**PARKS DEPARTMENT**

July 14, 2025

**Subject: Rising Moon Filing No. 1 Final Plat (SF2522)**

RISING MOON FILING NO. 1
 AS-REPLATTED

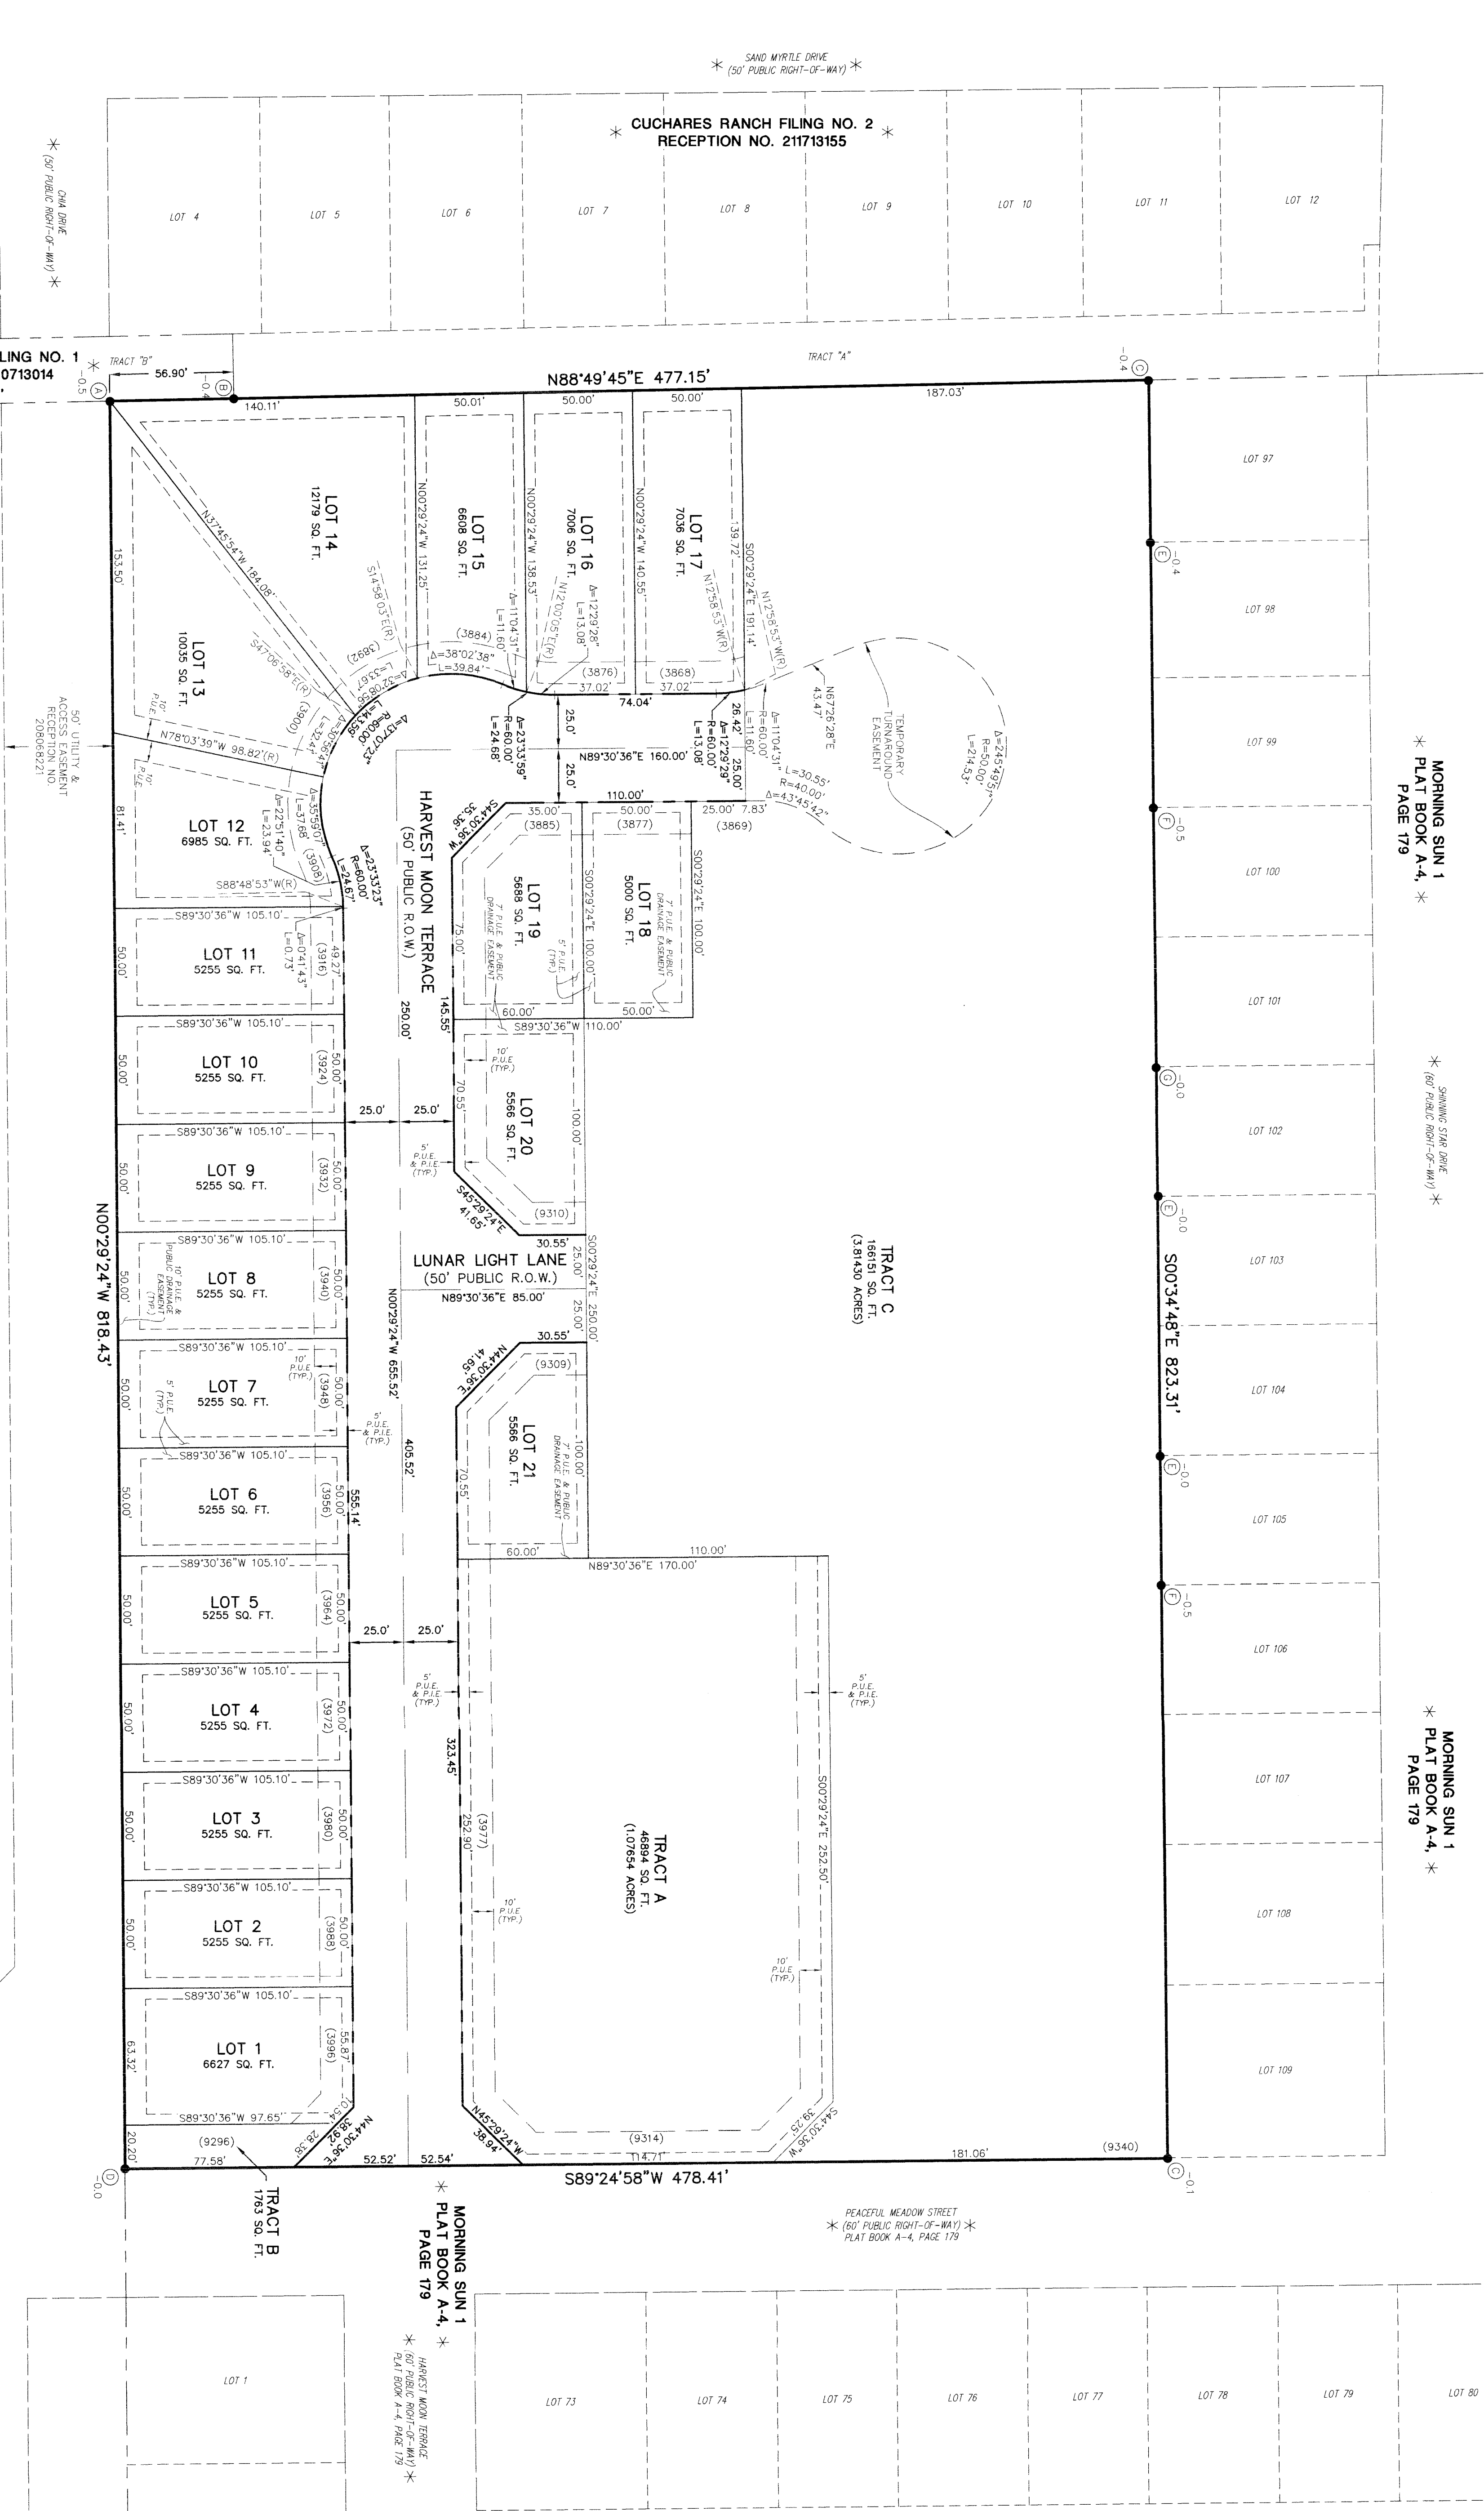
The project from preliminary plan to the submitted final plat has not changed and does not address El Paso County Parks previous comments or concerns. The final plat still lacks sufficient detail regarding the location of the proposed park site. Staff strongly recommends the park site be located outside of the proposed detention pond. Both the El Paso County

Engineering Criteria Manual and Drainage Criteria Manual outline requirements for detention facilities. An actively used park site is not compatible with stormwater detention.

Staff recommends that the applicant submit a more complete submittal that includes a detailed Landscape Plan with all possible recreational amenities including sidewalks, trails, common areas, and park site. As no park land or trail easement dedications are necessary for this development, staff recommends fees in lieu of land dedication for regional and urban park purposes, to be paid upon the recording of the forthcoming final plat.

*El Paso County Parks staff recommends that the Planning Commission and the Board of County Commissioners include the following conditions when considering and/or approving the Rising Moon Final Plat Filing No. 1: (1) provide a Final Plat with an associated Landscape Plan showing the proposed park site is not located with a detention basin; (2) fees in lieu of land dedication for regional park purposes in the amount of \$20,705 and urban park purposes in the amount of \$12,423 will be required at time of the recording of the forthcoming Final Plat.*
